**Re: Application: SSI 7485**

In the short timeframe that has been made available, I am writing in relation to the proposed modification to M4-M5, Mod 2 The Crescent overpass.

Figure 4-6 Elevation: Indicative view of Rozelle Rail Yards Pedestrian and Cycling Green Link

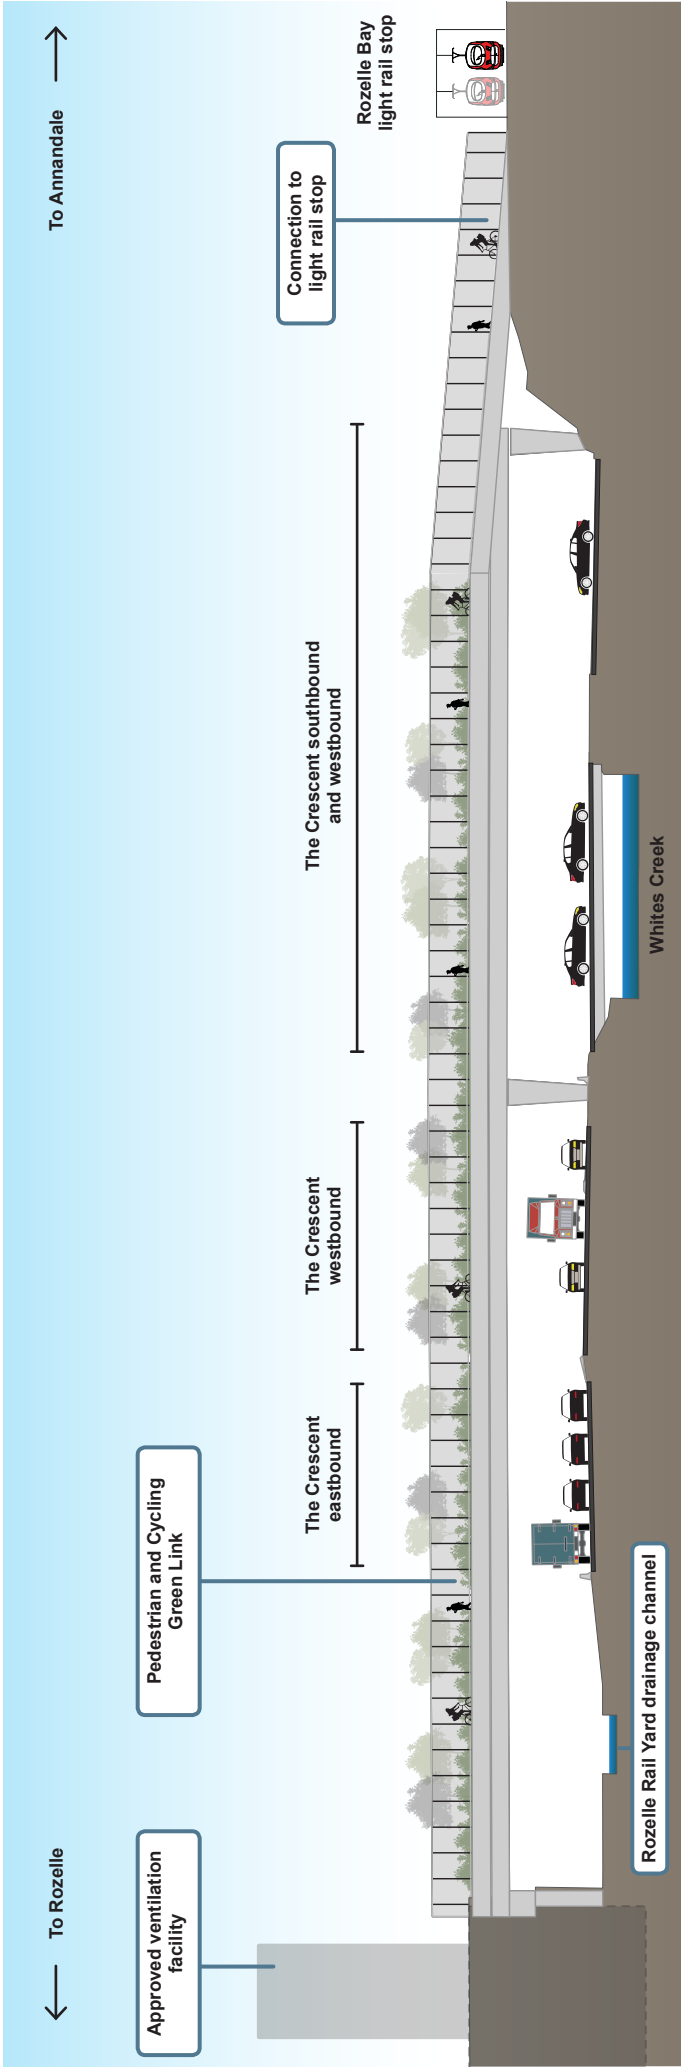
**The new proposal suggests significant and negative changes to the previously approved "Greenlink" pedestrian and cyclist access to the Glebe foreshore.**

The approved EIS Greenlink was intended to create a continuous green open space from Rozelle and Annandale to the foreshore. Pedestrian and cycle connections need to be safe and direct. **However, the new proposed changes will end this vision and also erode the whole attractiveness of the heralded green "Bays precinct".**

Figure 4-7 Elevation: Indicative view of the shared user path bridge

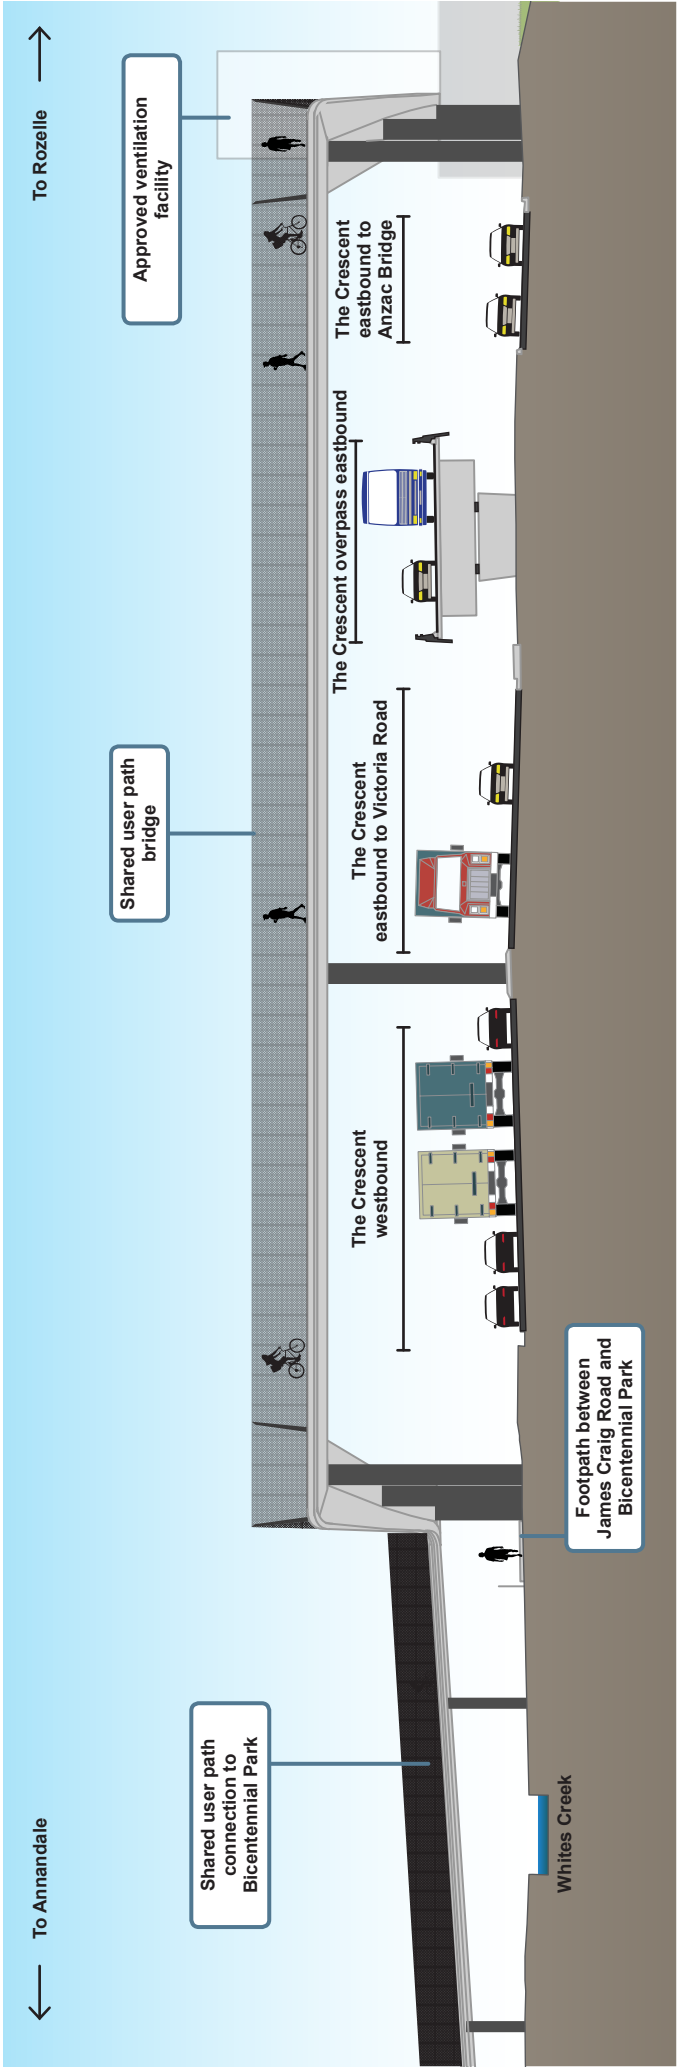
This will finish the ready accessibility and safety in movement to the foreshore by locals. Easy movement of people will be blocked by a large, noisy, and polluting exposed roadway. People who want to access the area and park will now have to negotiate multiple sets of traffic lights and will be made to travel in a circuitous way along an unattractive raised concrete walkway.

This will be an unpleasant and potentially unsafe cramming together of pedestrians (including young children and the elderly), hundreds of light rail commuters, families with prams, dog walkers and their dogs, joggers, and cyclists, who obviously should not be huddled together in an elevated walkway.
